Recommendation Report for Lawful Development Certificate for a Proposed Use or Development

REF NO: P/116/20/CLP

LOCATION: 16 Lagoon Road
Pagham
PO21 4TJ

PROPOSAL: Lawful development certificate for a Proposed timber framed detached garage

Mr. P. Barnes
16 Lagoon Road
Pagham PO21 4TJ
PROPOSED ELEVATIONS
Date; October 2020 Scale 1:100

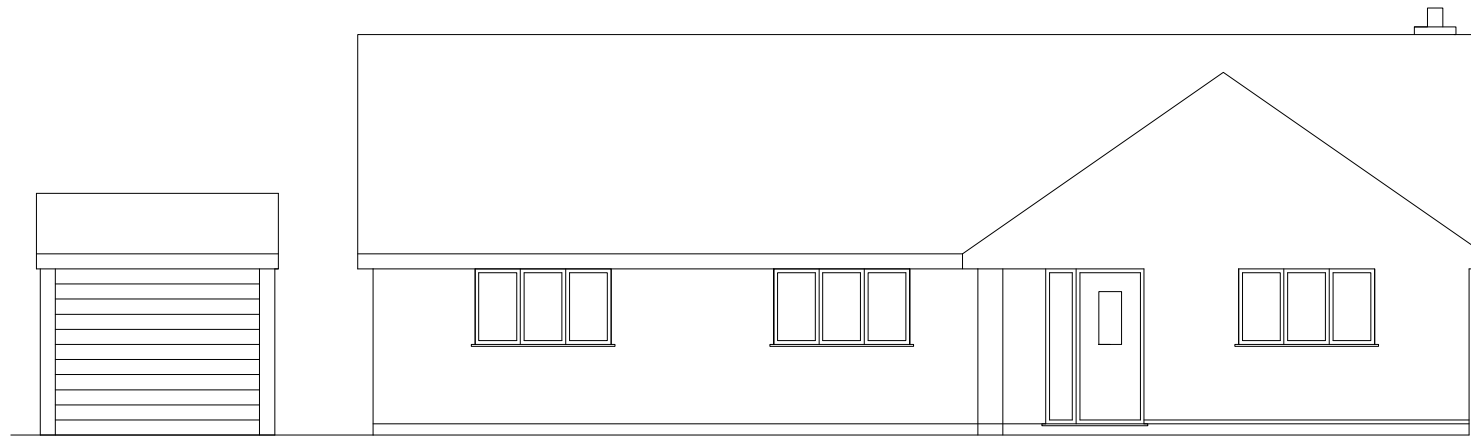
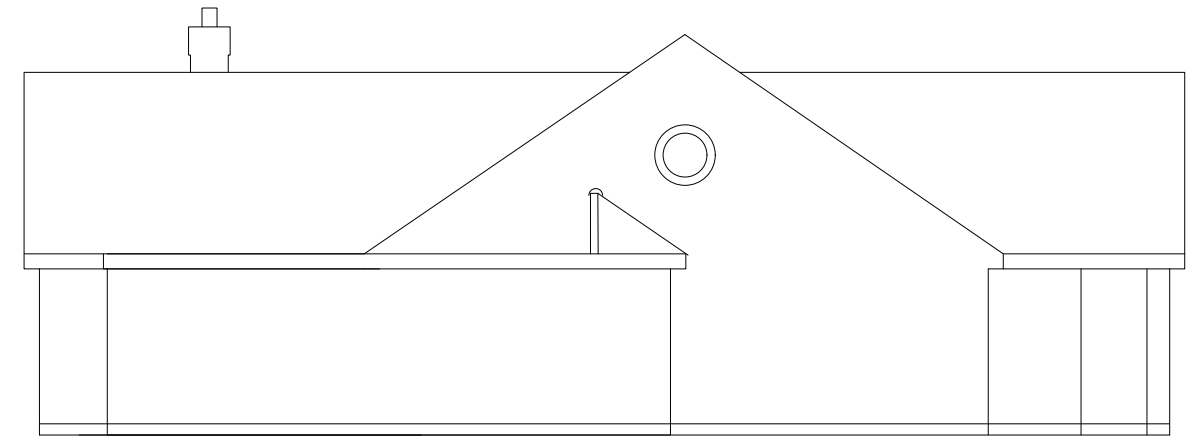
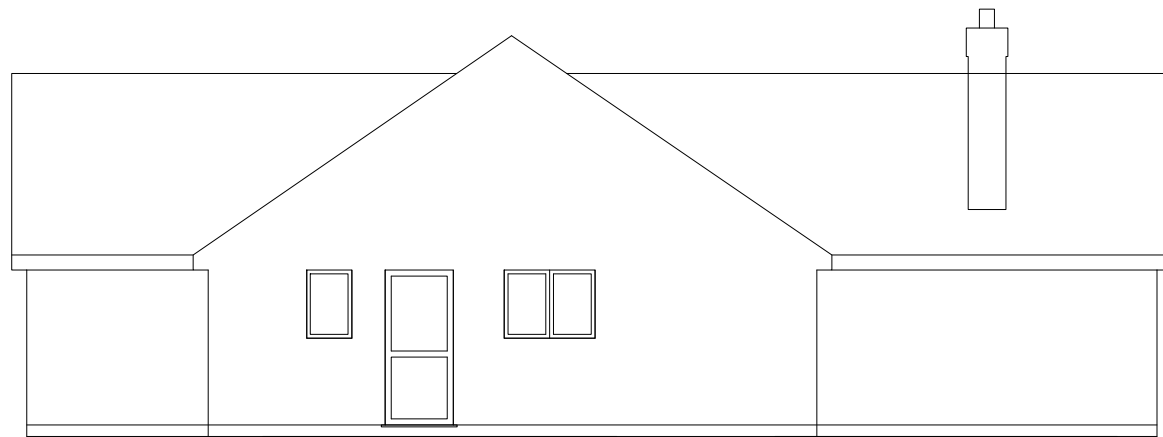
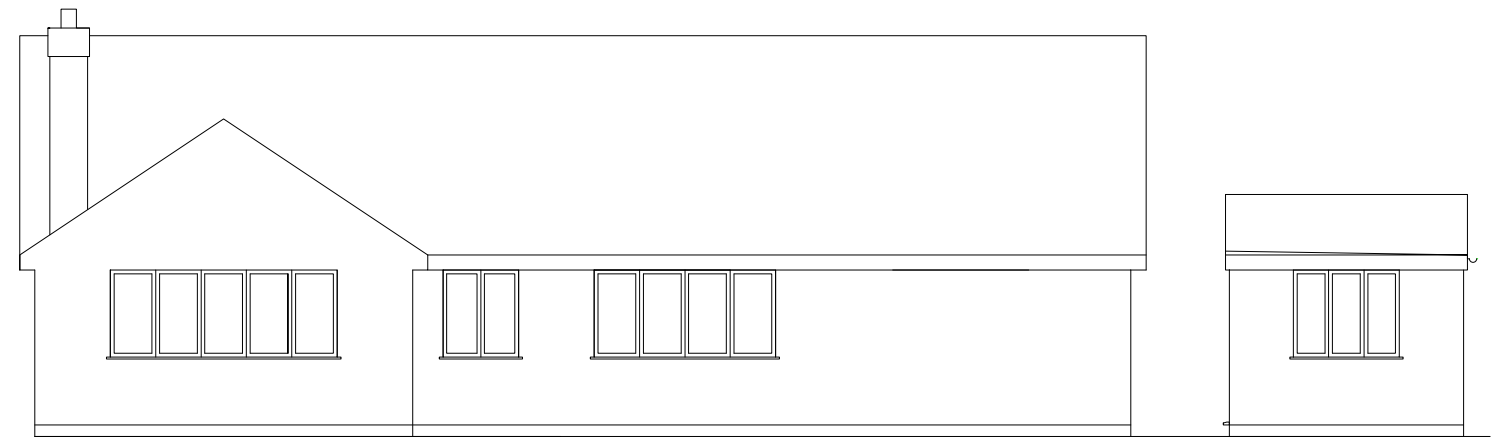
The proposed garage does not comply with relevant section (e) by virtue of it being within 2m of the boundary and being over 2.5m high, and is not considered permitted development and as such does require the submission of an application for full planning permission.
